Application for a non-material amendment following a grant of planning permission.

Number	61
Suffix	
Property name	
Address line 1	Longfield Road
Address line 2	
Address line 3	
Town/city	Tring
Postcode	HP23 4DF

Re-cladding of existing two storey ancillary garden building and new velux windows.

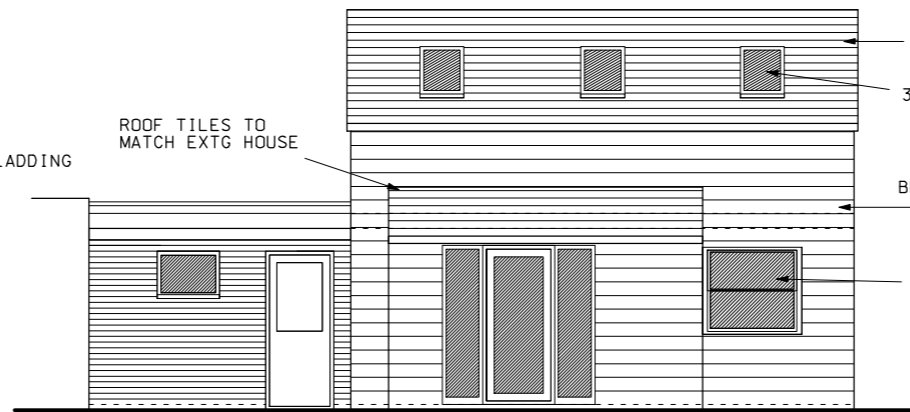
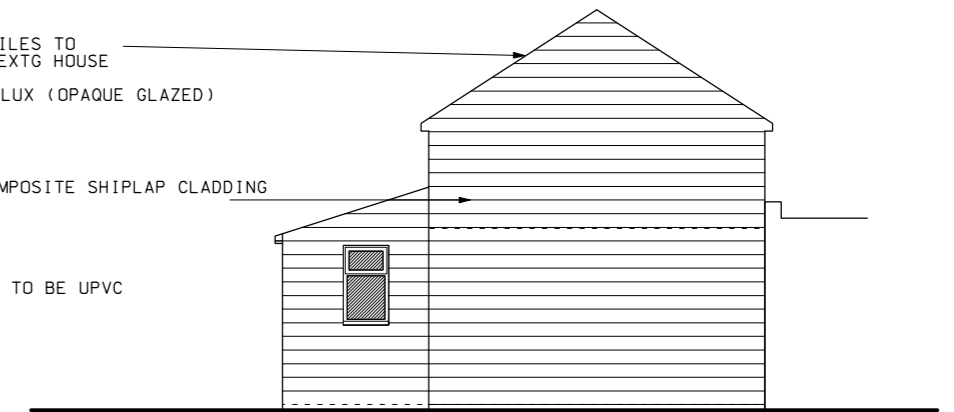
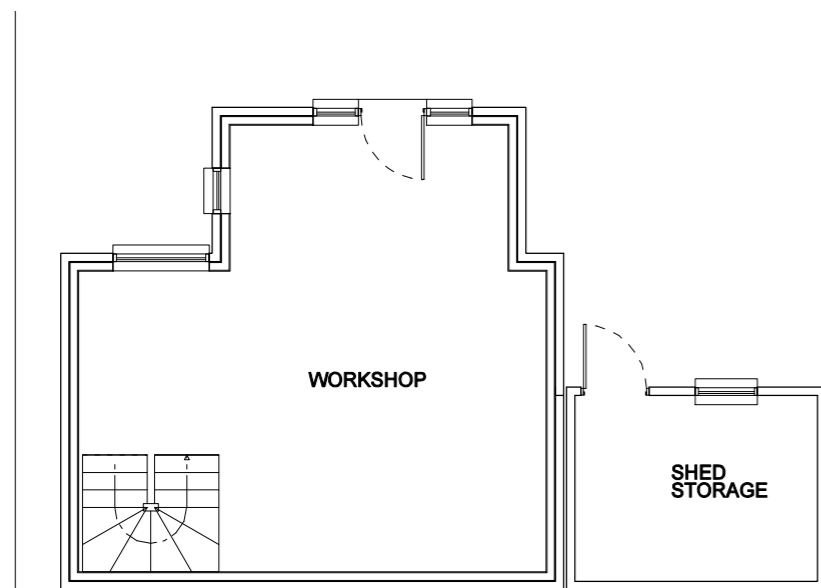
The original application stated "roof tiles to match extg house" would be used. These tiles are of a red concrete construction. I wish to use black slate instead.

I believe that black slate would be much more subtle and sympathetic to the local environment than the fairly garish red tiles that are on the house.
